Kingston Parish Council
Mrs V Knight
33 The Ridings
East Preston
West Sussex
BN16 2TW

Town & Country Planning Act 1990 (as amended)
Town & Country Planning (Development Management Procedure) (England) Order 2015

Replacement of existing studio building, adjacent to house, with new studio building, to be used as extension to house. This application may affect the setting of a listed building.

Kingston Corner Brookside Road Kingston

Drawing Title:
GA - Proposed Elevations

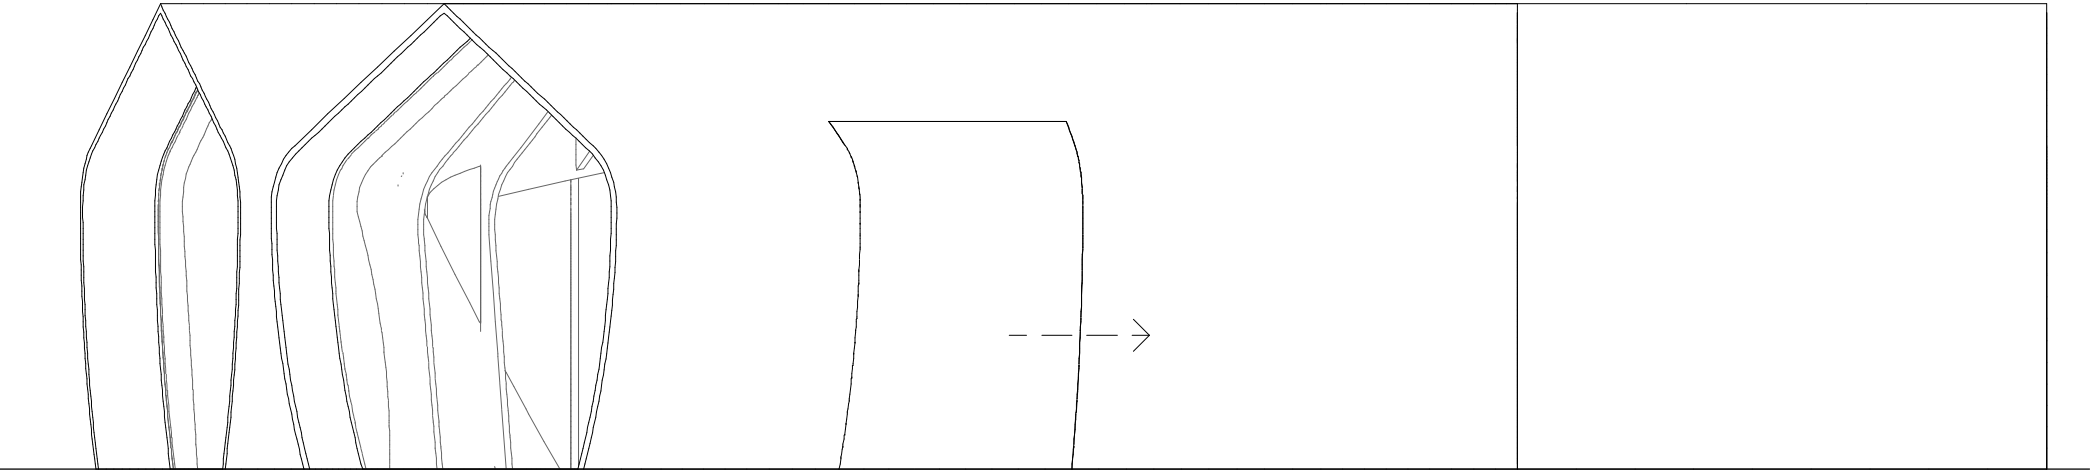
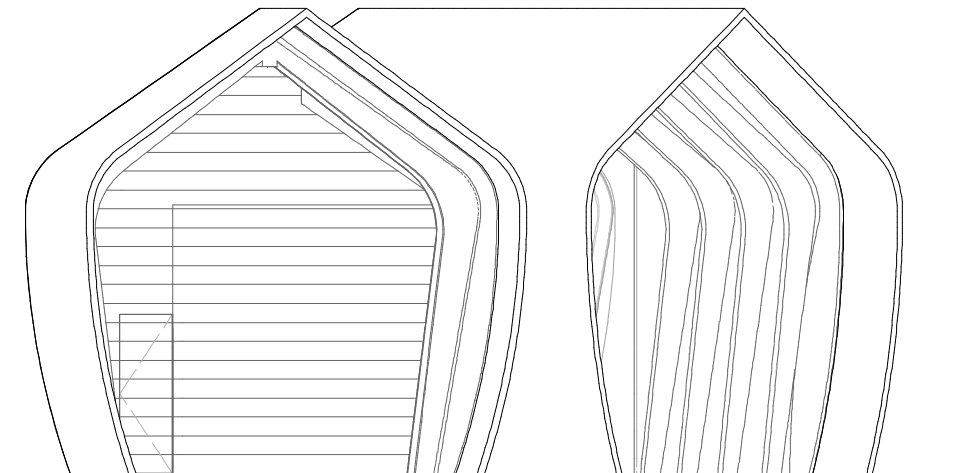
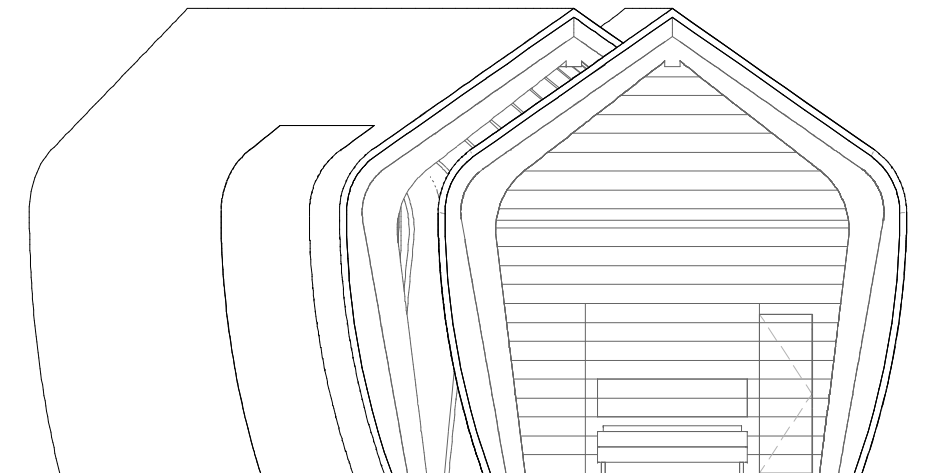
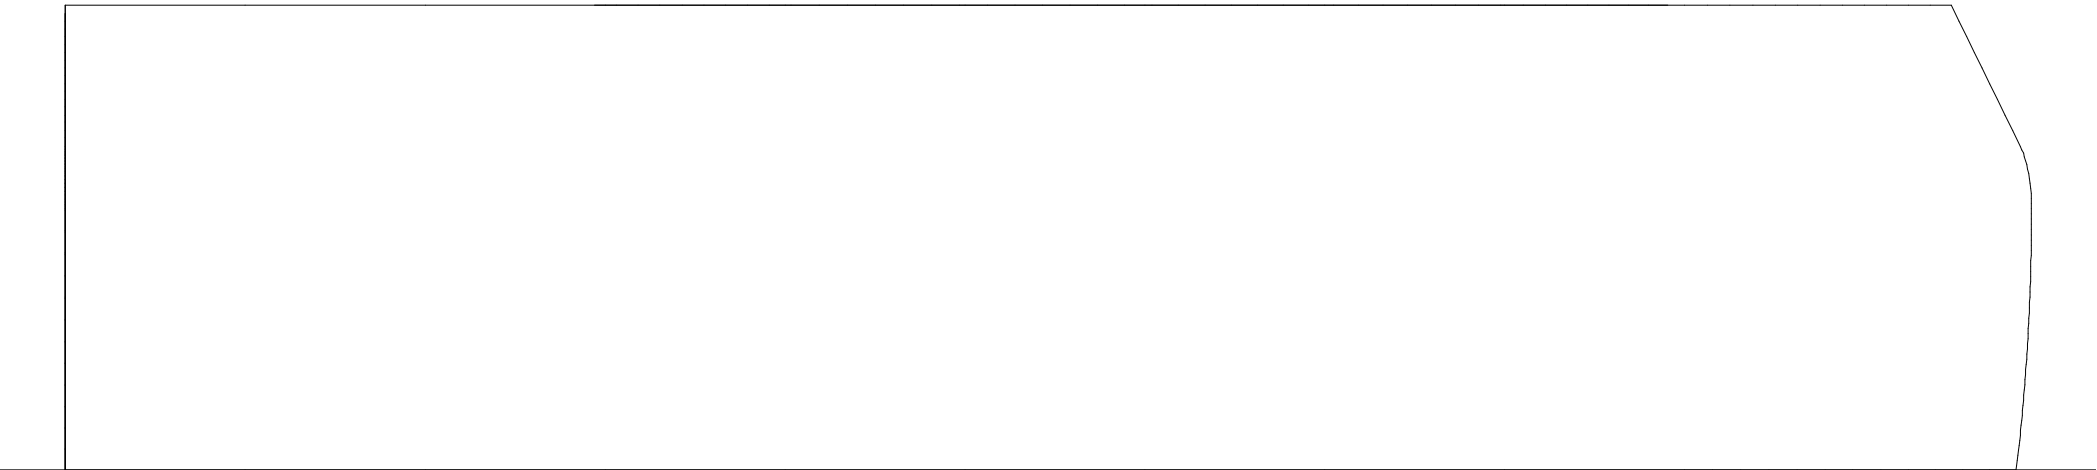
- *It is an overdevelopment of the site*
- *It is visually out of character and out of scale to the existing dwelling with materials that do not match the existing dwelling*

- *It is detrimental to the amenity of the street scene and the character of the area*
- *It is too close to the boundary with the neighbouring property (a Listed Building)*

- *It will be overbearing and intrusive to the neighbouring property*
- *It will adversely affect the setting of a Listed Building given its size, position, design and unsympathetic use of materials.*

- *The application refers to replacing an existing garden studio: this is a modest single storey, flat roofed building of flint designed to integrate with the flint wall that runs alongside it, that is referred to in earlier planning applications for Kingston Corner as a garden store. The proposed replacement building uses materials that are unsympathetic to the existing, and is a significant increase in size both in height and mass (its footprint appears to be well over three times the size and it has the addition of a mezzanine level with pitched roof).*

- *Given its distance from the existing dwelling, its large size and height, position forward of the existing dwelling, and that the materials and design do not match the existing dwelling, this cannot be viewed as subsidiary to the existing dwelling. It is not an annex; instead it is creating a substantial, large self-contained building with a design that is not in keeping with its surroundings.*
